**Your ref:** 3/2021/0240  
**Our ref:** DC/21/1401  
**Date:** 31-MAR-21

**Location: Bowland Wild Boar Park Wardsley Road Chipping PR3 2QT**  
**Proposal: Discharge of condition 6 (Construction Management Plan) of planning application 3/2020/0579.**

Site plan

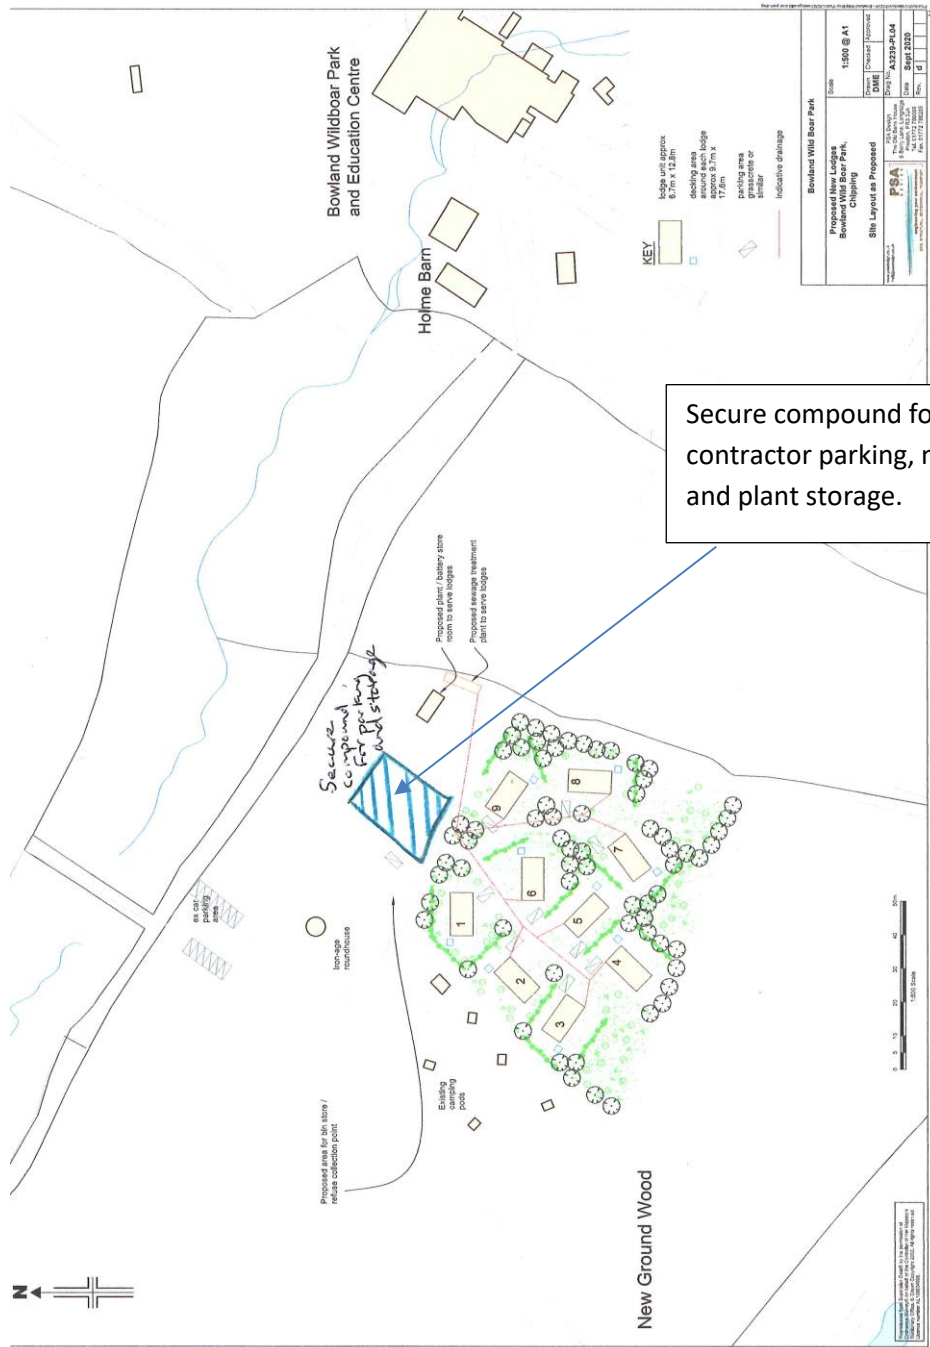
We still have concerns over the proposed development and require further detailed information relating to:

- Information relating to the depth, location of the existing assets and the maximum imposed loads at the crown of the main from any construction loading;
- Protection measures proposed for the mains, particularly where it will be crossed by construction traffic, delivery vehicles and potentially refuse wagons which may exceed any weight limits imposed on our asset;

- Full details of the proposed plant/ battery store and package plant to ensure there is no contamination risk to the water supply;
- Evidence to demonstrate mitigation measures have been implemented and the proposed works is in accordance with our Standard Conditions guidance (a copy is enclosed); and
- Clarification of the distance from the site compound location to the water main easement is required to assess any potential loading, access and contamination issues.
